WEST SUSSEX COUNTY COUNCIL CONSULTATION

TO:	Arun District Council FAO:M Tomalova
FROM:	WSCC - Highways Authority
DATE:	20 January 2022
LOCATION:	99 Victoria Drive Bognor Regis PO21 2DZ
SUBJECT:	BR/3/22/DOC Approval of details reserved by condition imposed under BR/281/18/PL relating to conditions 3-Arboreal meeting, 6-Construction Management Plan, 7-landscape scheme, 8-colour scheme of materials and/or finishes, 9-new screen walls and/or fences, 10-covered and secure cycle parking spaces, 12-dustbin enclosures, 13-electric vehicle charging & 14-decentralised, renewable and low carbon energy supply systems.
DATE OF SITE VISIT:	n/a
RECOMMENDATION:	No Objection
S106 CONTRIBUTION TOTAL:	n/a / £ See below for breakdown.

PROPOSED CYCLE STORAGE

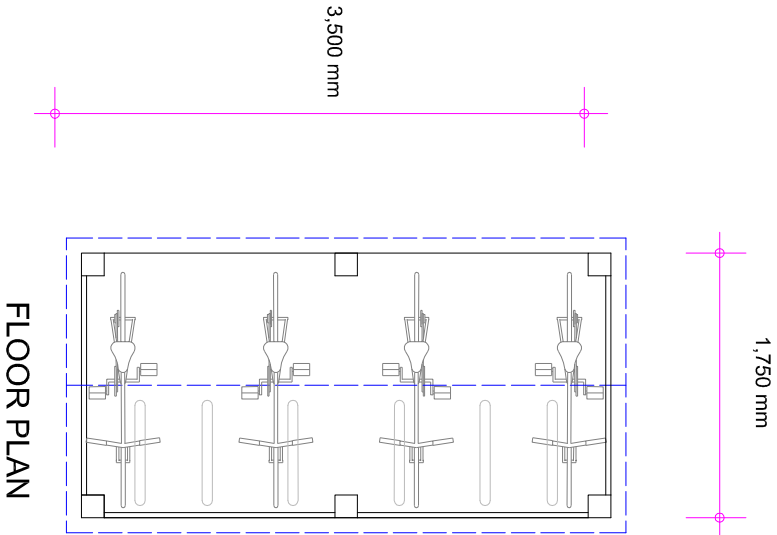
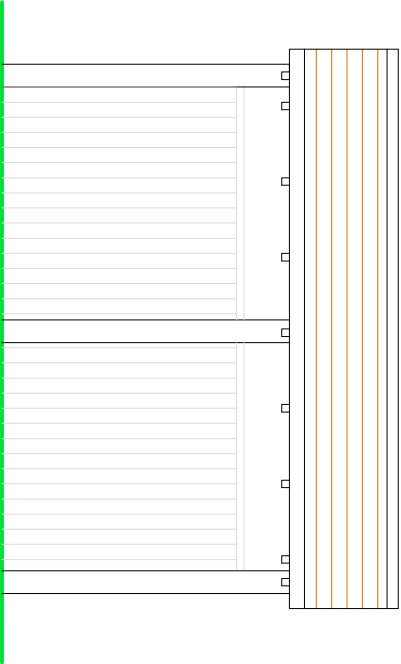
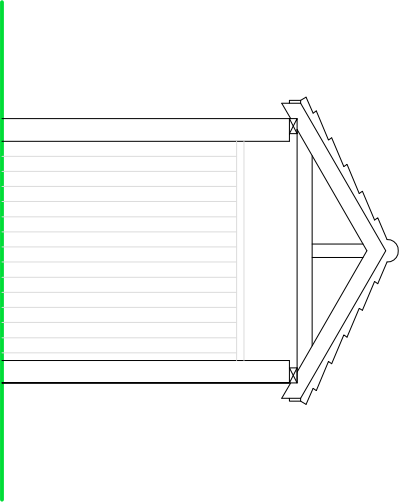
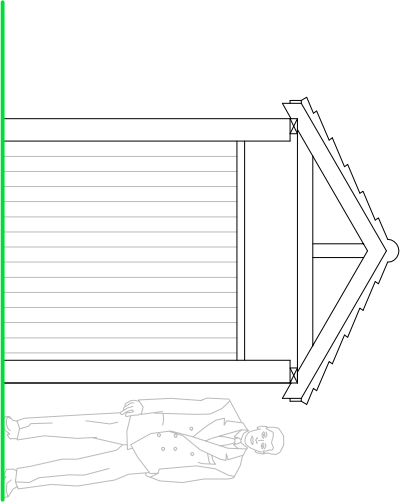
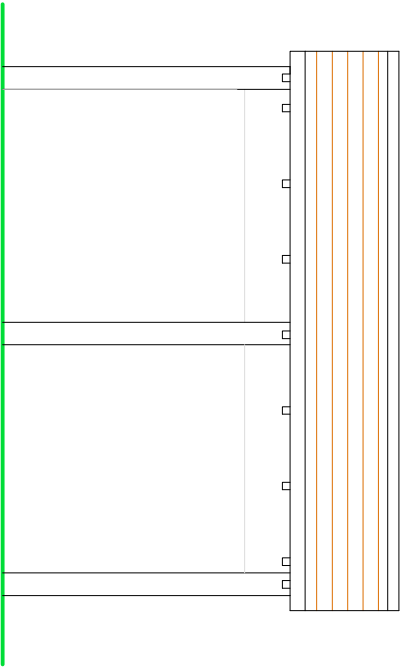
DOC 10 – Cycle Parking Spaces

Condition Discharged. Provision for 6 hoop style stands have been provided within a secure area.

CONSTRUCTION MANAGEMENT SITE PLAN

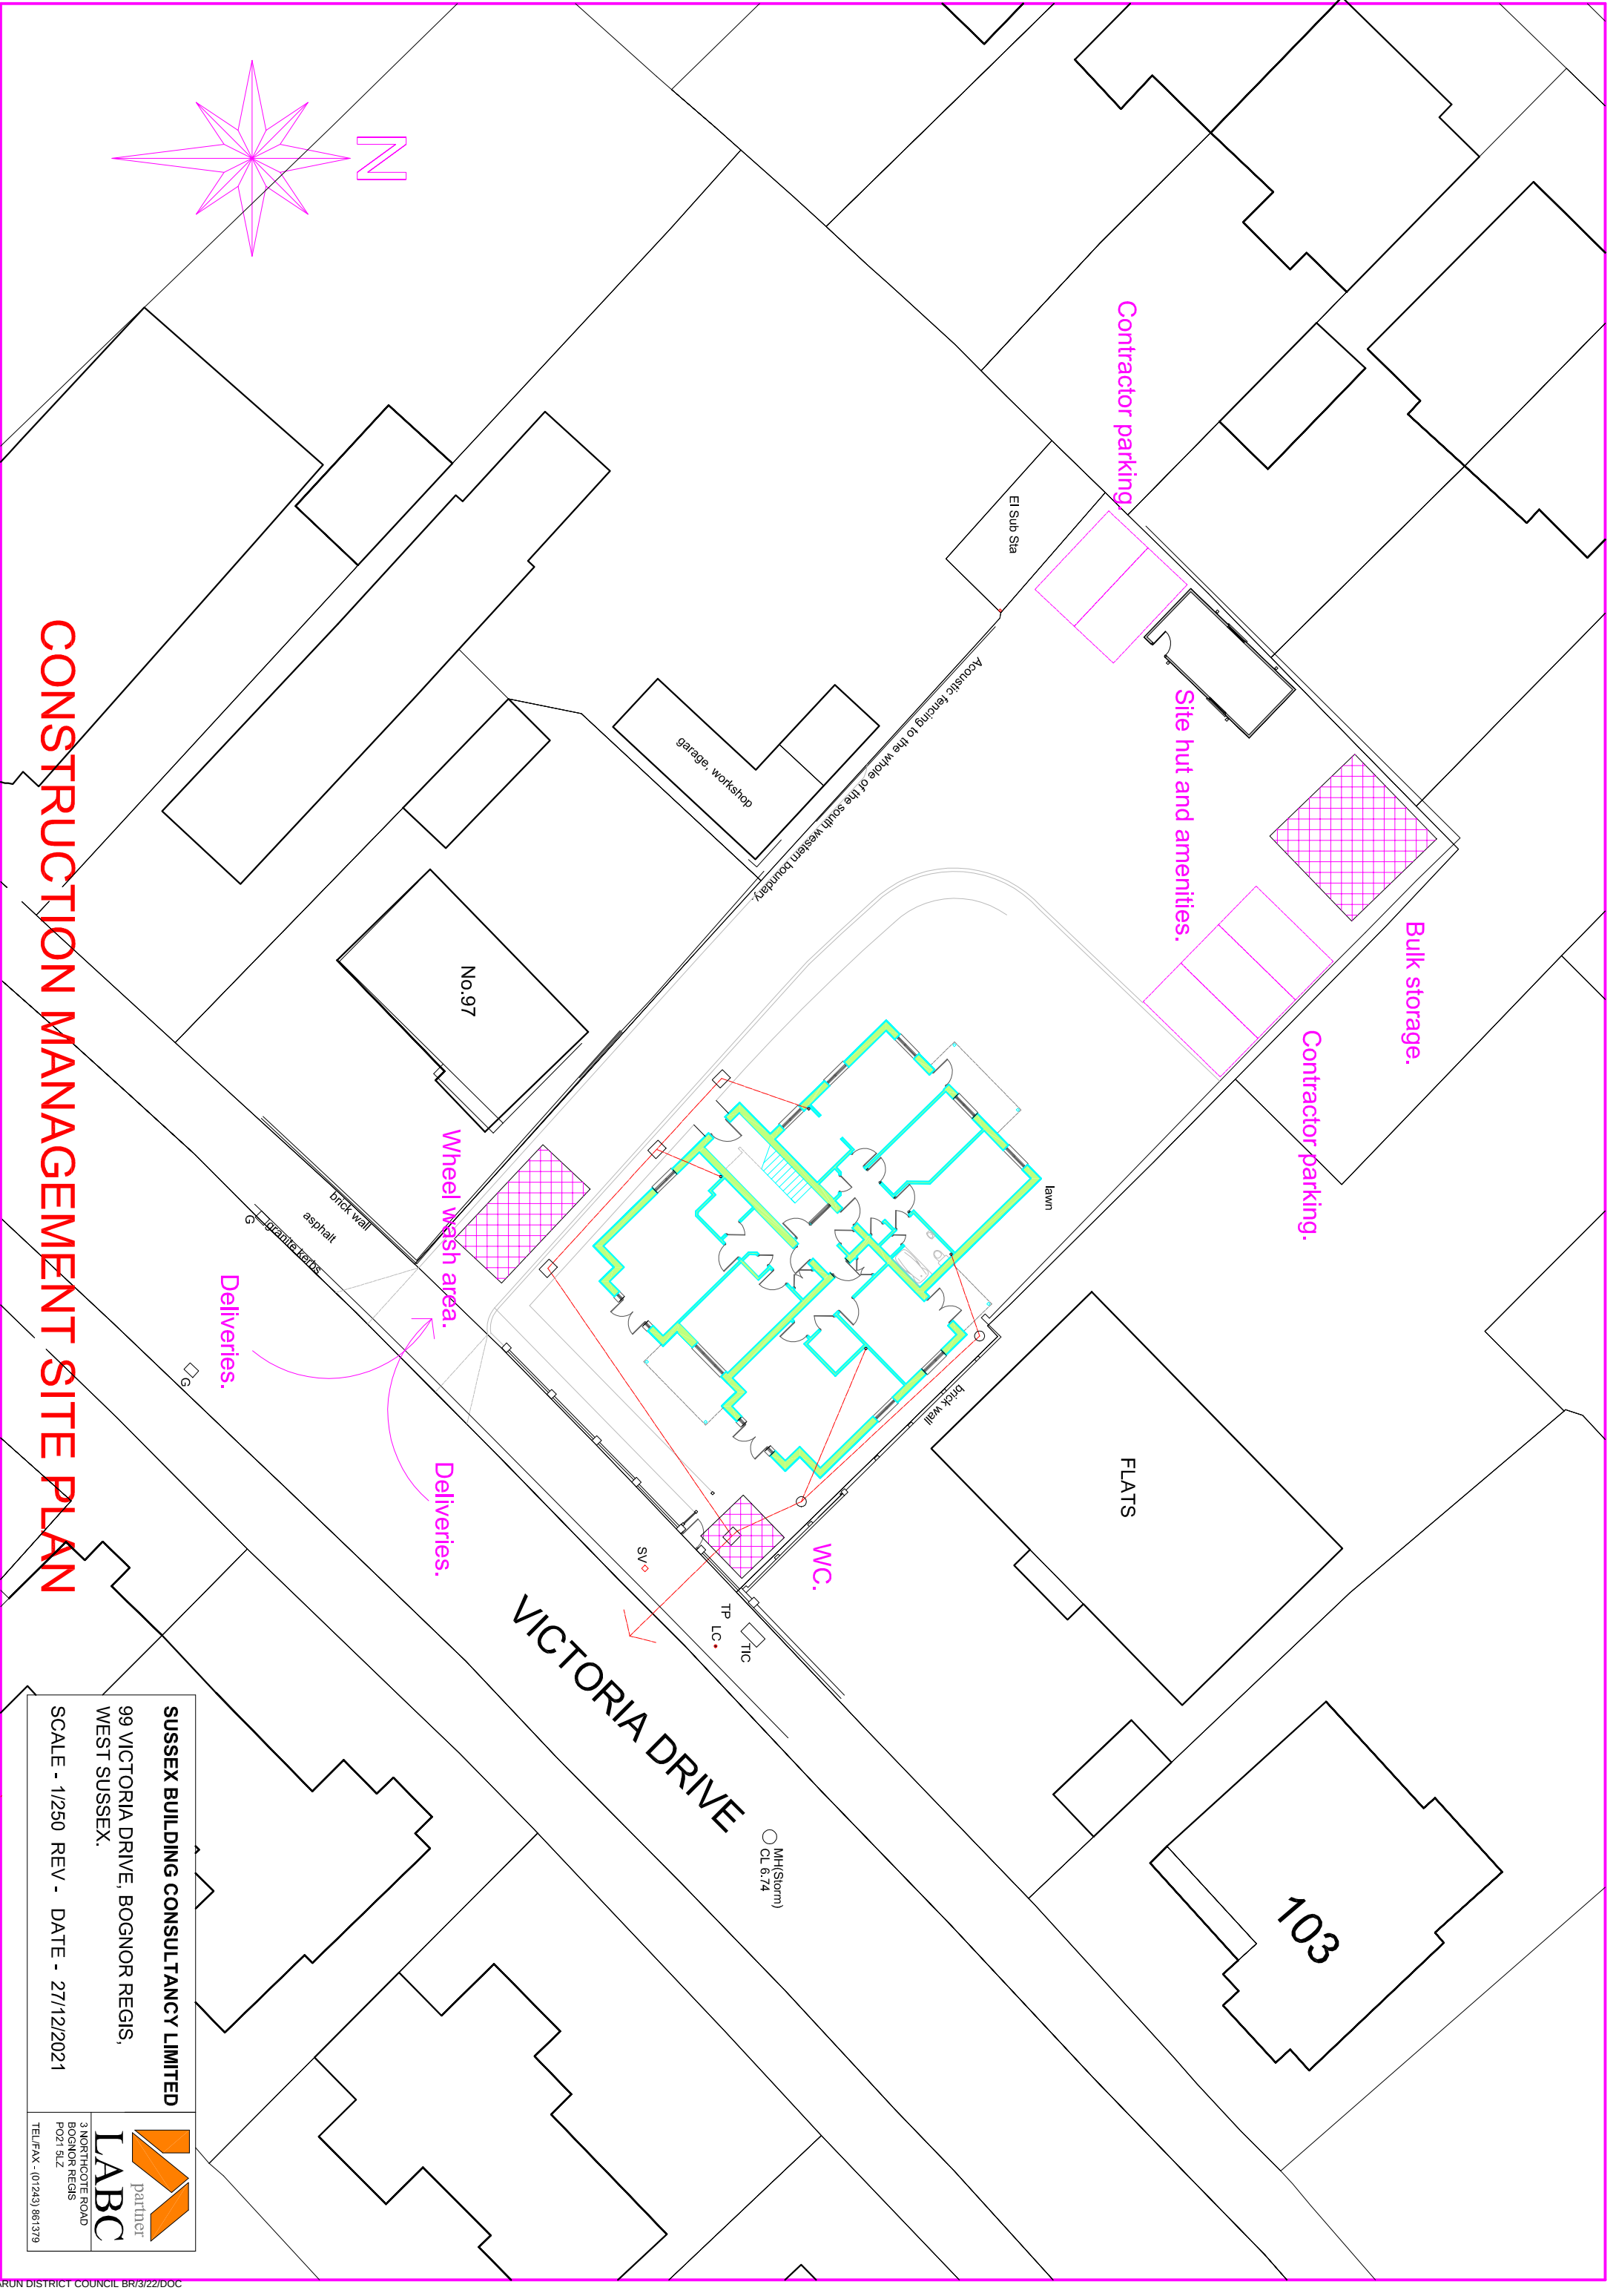
DOC 6 – CMP

Condition discharged. All points regarding the condition have been addressed and a site plan submitted.
